## Plot 23 Height:

### From “Equivariant Height, or Marginally Lower” to Approximately 3.64 Metres Higher

Before application **2026/91657** is determined, I ask the Council to require the applicant or developer to provide:

Rev B	03/06/2026	Updated for planning submission.		
Rev A	24/09/2025	Minor amendments, dimensions added.		
Project :		Housing at Lingards Road, Slaithwaite.		
Client :		SB Homes.		
Drawing :		Plot 23 - OPTION 1.		
Scale :		1:100.	Date :	May 2025
Dwg No :		2019 572 Sk 15	Rev :	B

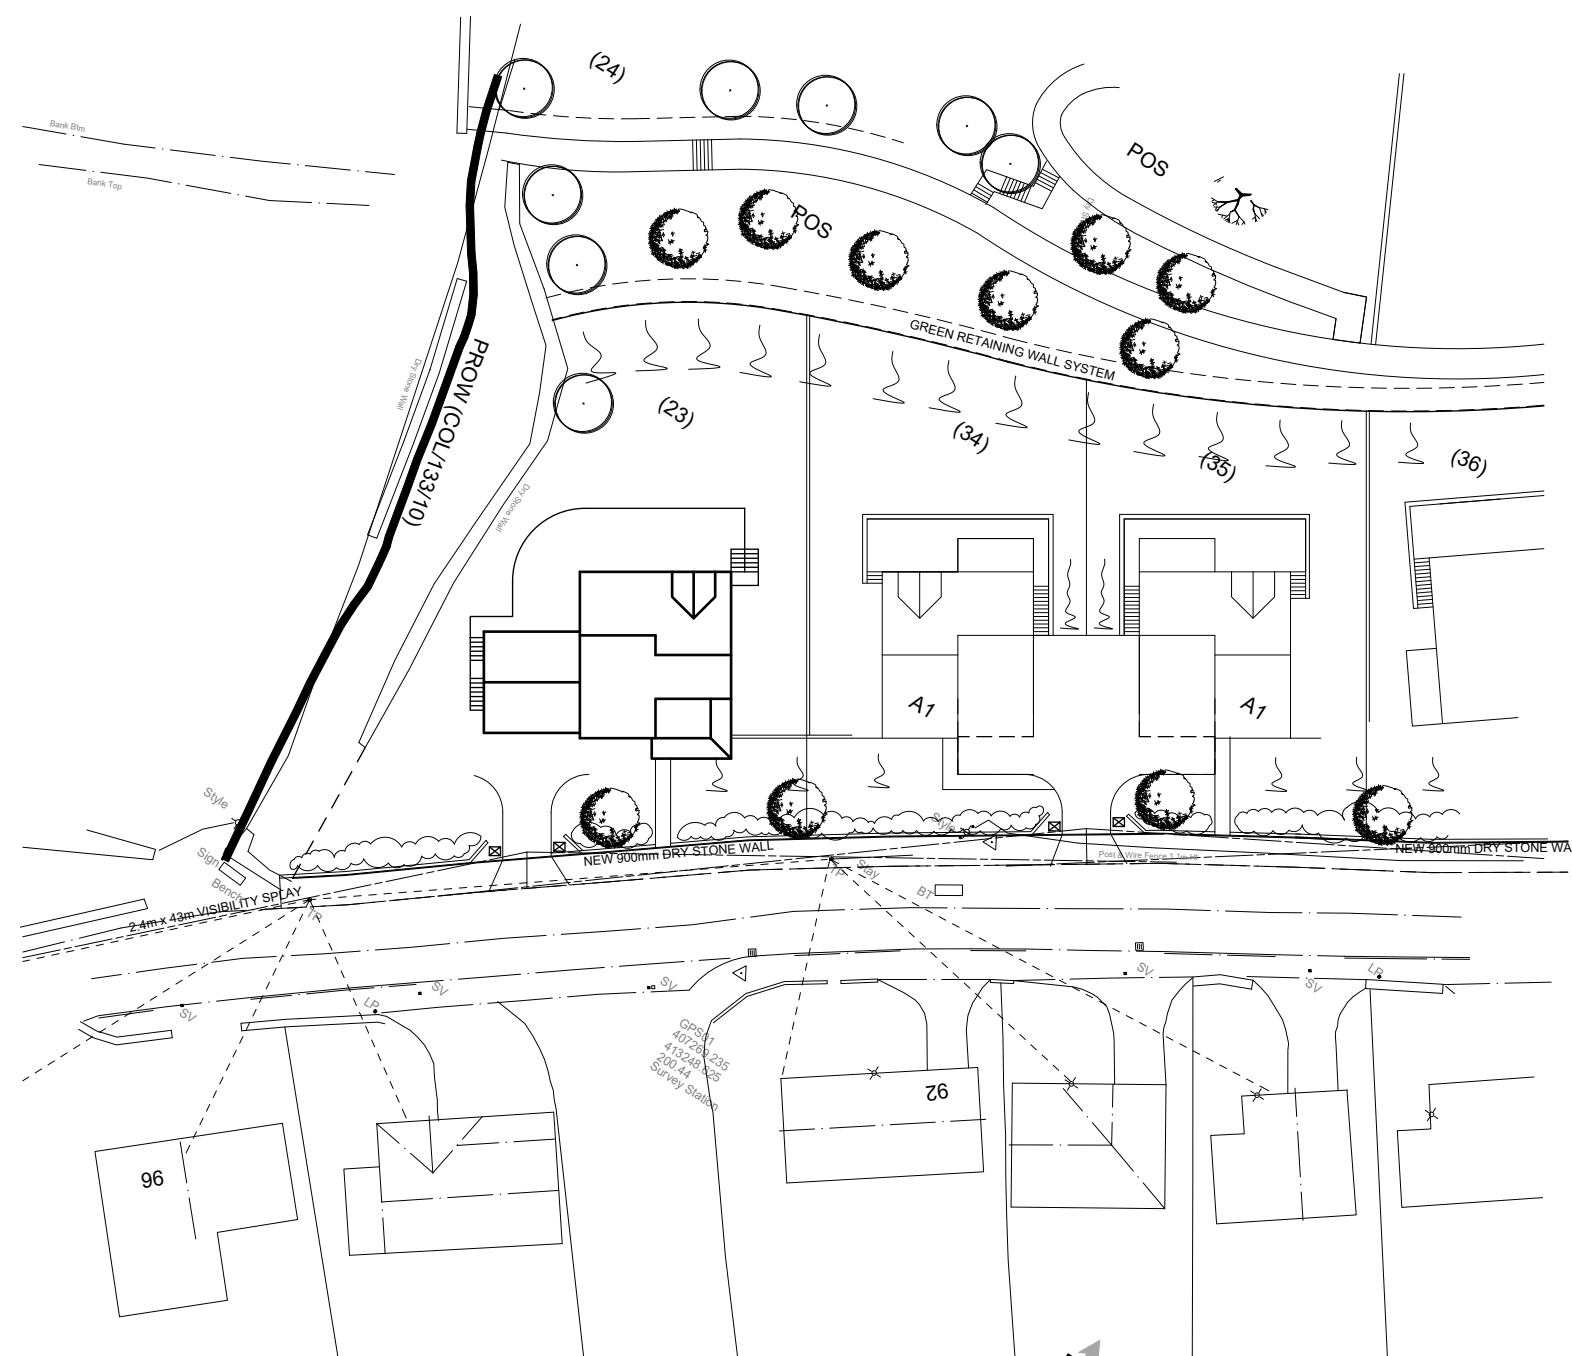
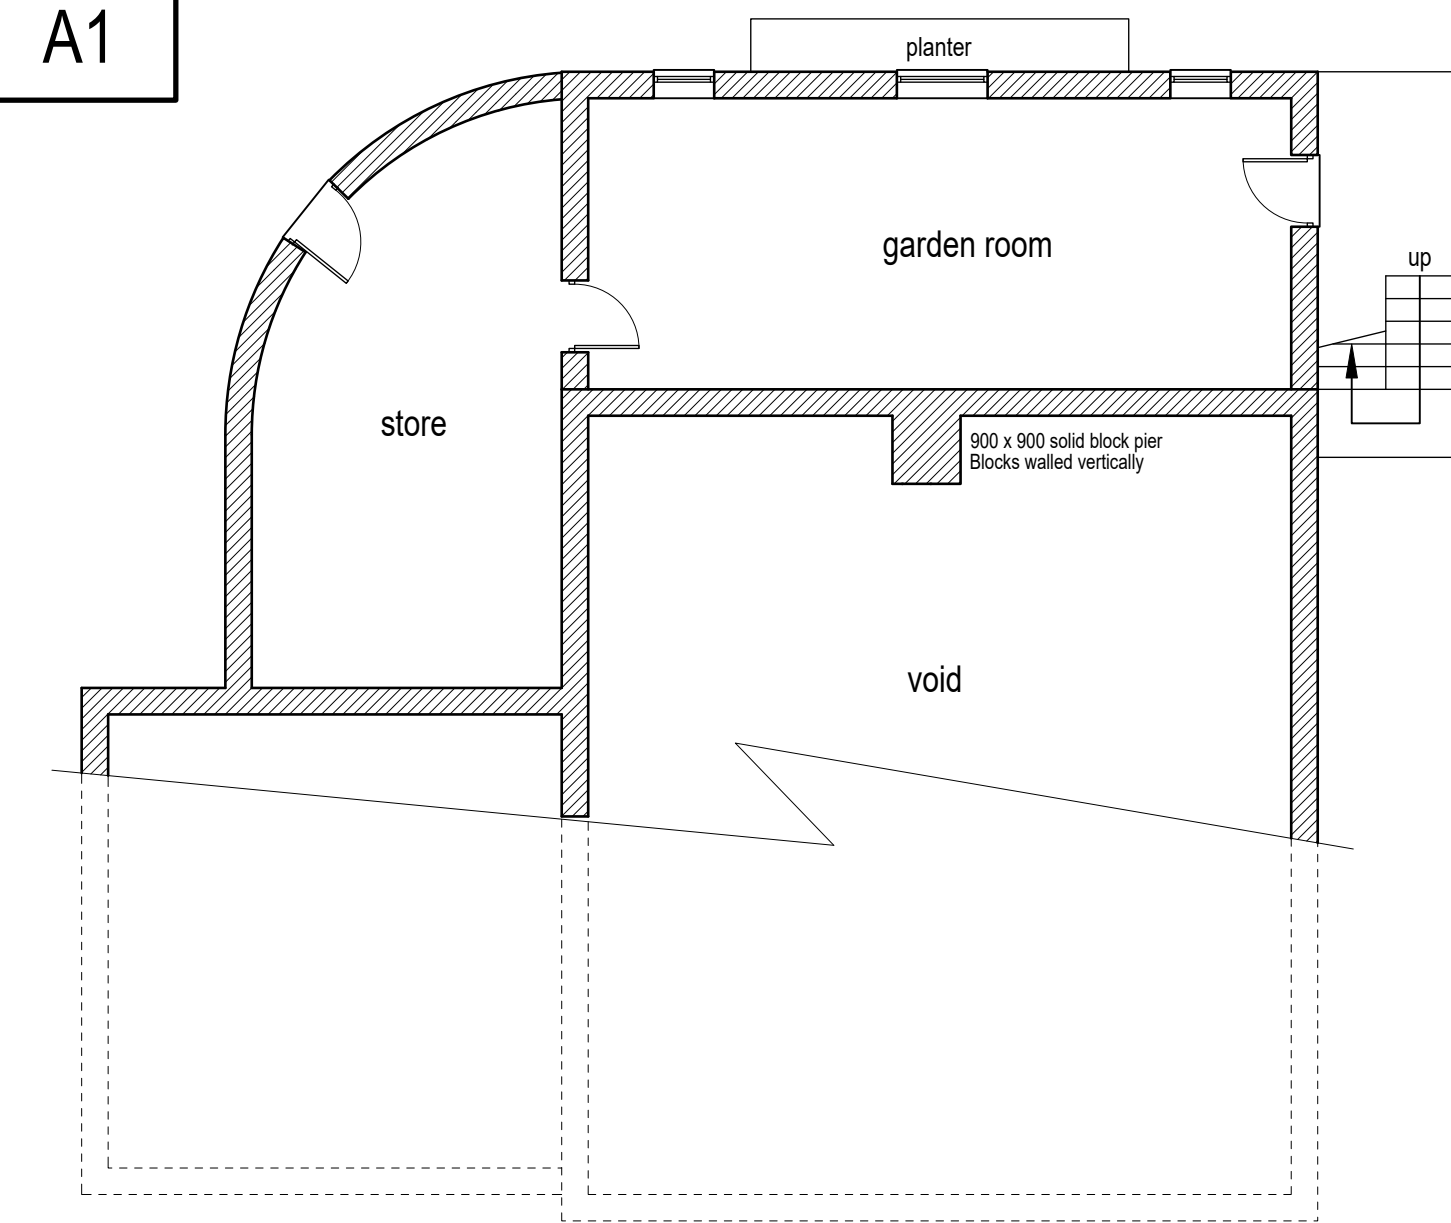
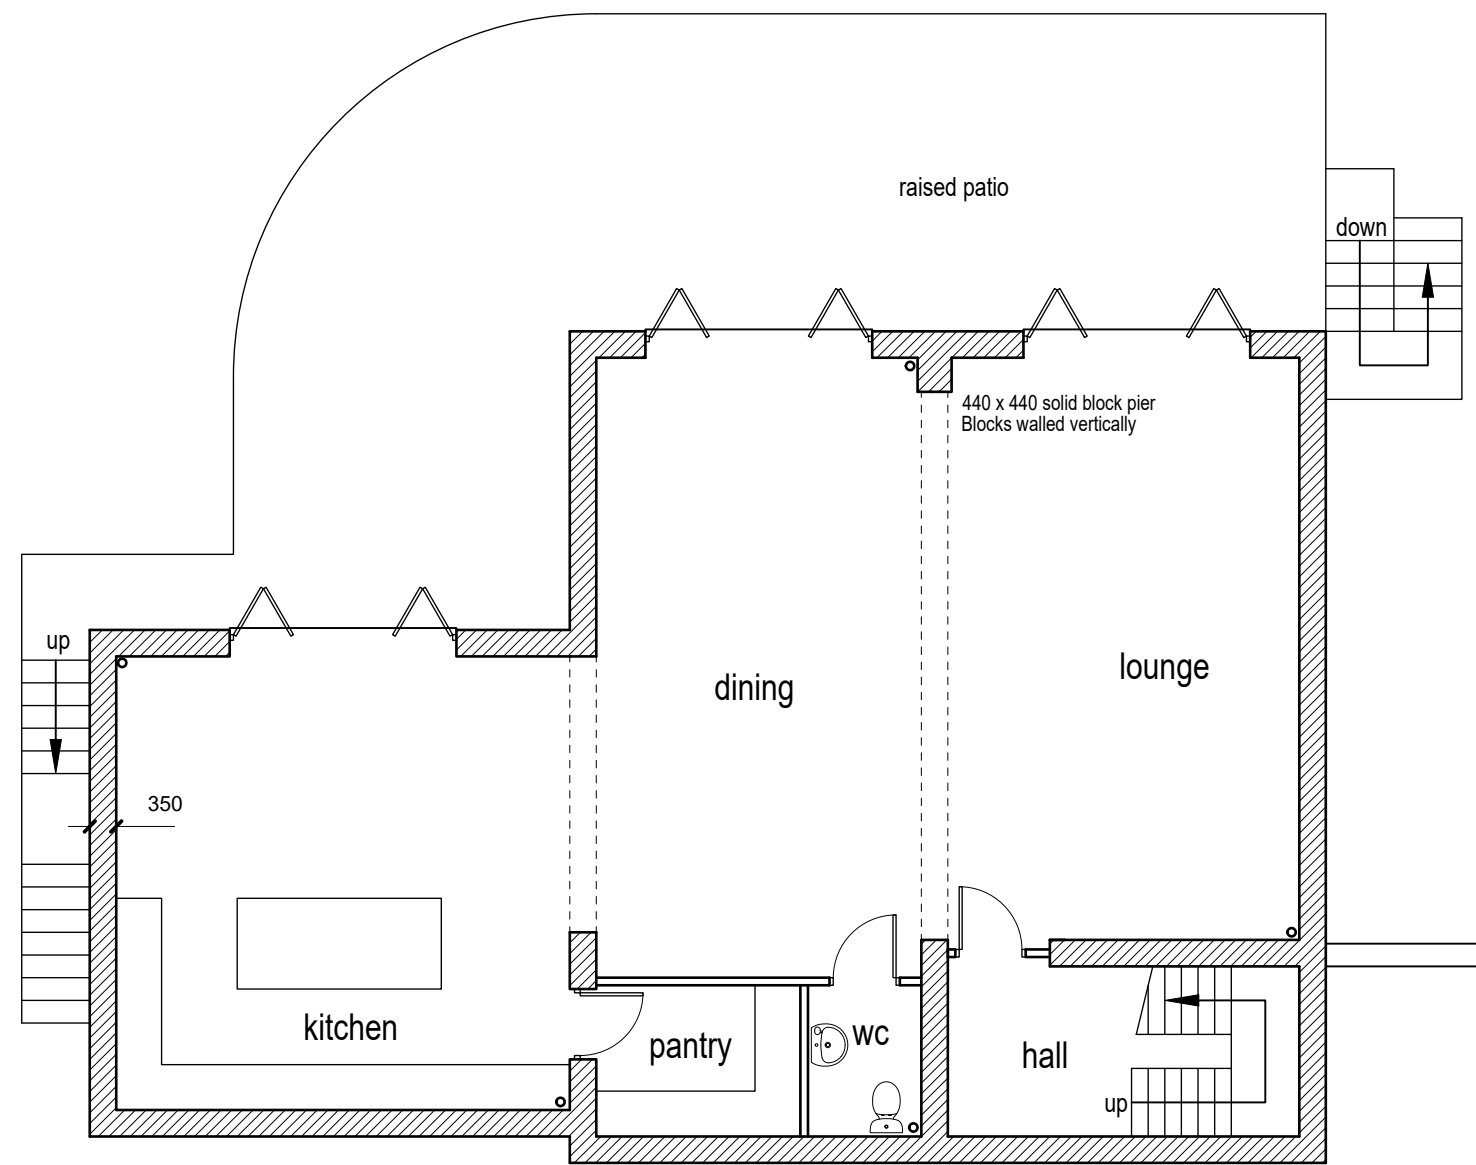
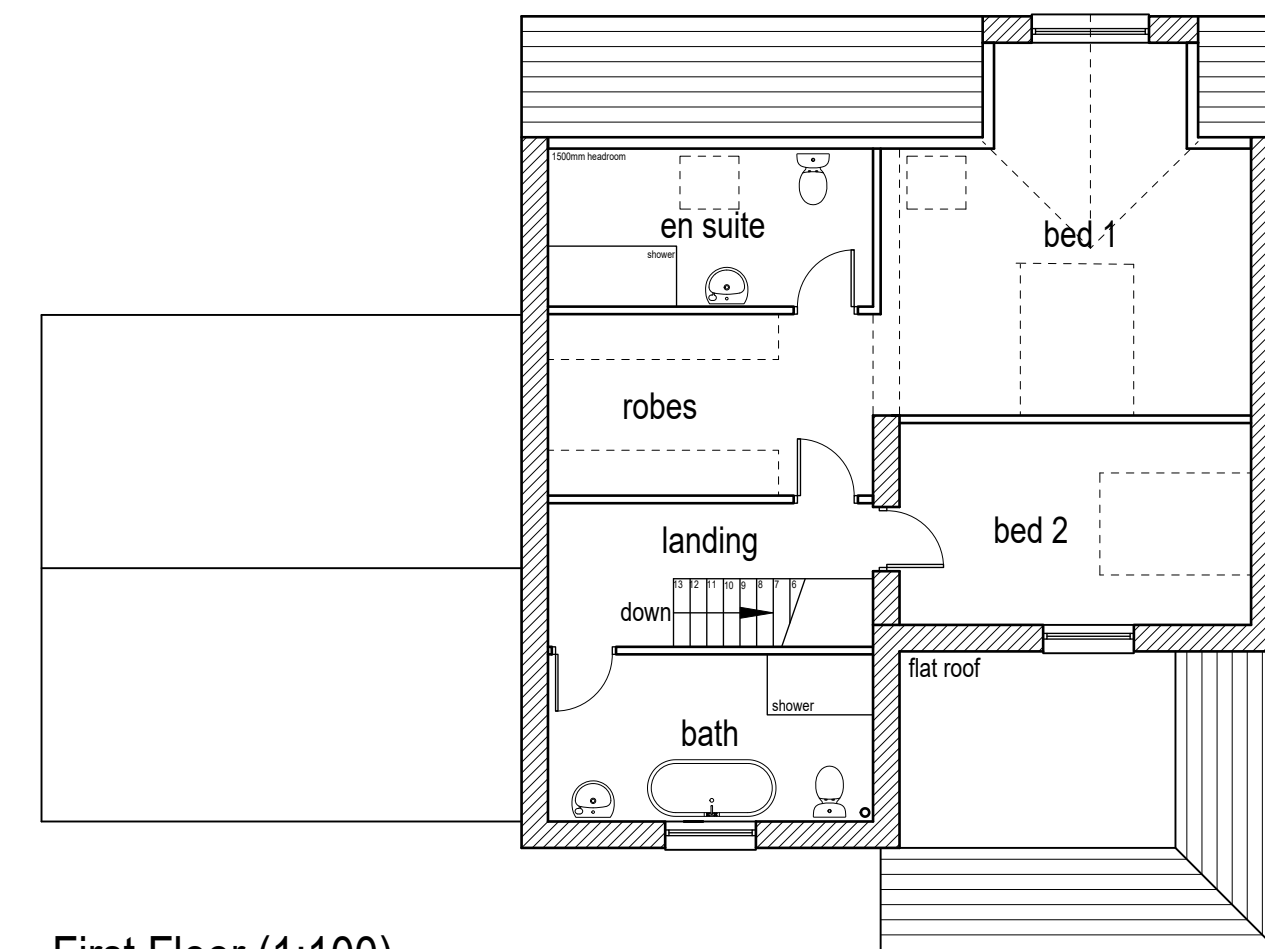
The relationship between Plot 23 and No. 92 does not appear consistent with that statement.

- using the submitted ground-floor elevation, the ridge of Plot 23 would already be approximately **2.64 metres higher** than the ridge of No. 92; and
- if the apparent approximate **1 metre increase** in Plot 23’s ground-floor level is confirmed, its ridge would be approximately **3.64 metres higher** than the ridge of No. 92.

The substantially greater ridge height of Plot 23 will be experienced directly within the outlook from a habitable room at No. 92. Viewed in this direct relationship, the additional height would materially increase Plot 23’s visual presence, dominance, sense of enclosure and effect upon the outlook from No. 92.

The Council should independently verify Plot 23 against the submitted drawings, including:

- its lower-floor level;
- its ground-floor level;
- the garage-threshold level;
- the relationship between the garage and driveway;
- its eaves level;
- its calculated ridge level; and
- its relationship with No. 92.

Raising a building of this scale by approximately 1 metre has real-world consequences. The increase would not affect only an isolated datum or one part of the structure. If the submitted building height is carried upwards from the apparent built level, the whole dwelling—including its principal floors, eaves and ridge—would sit approximately 1 metre higher than shown on the submitted drawings.
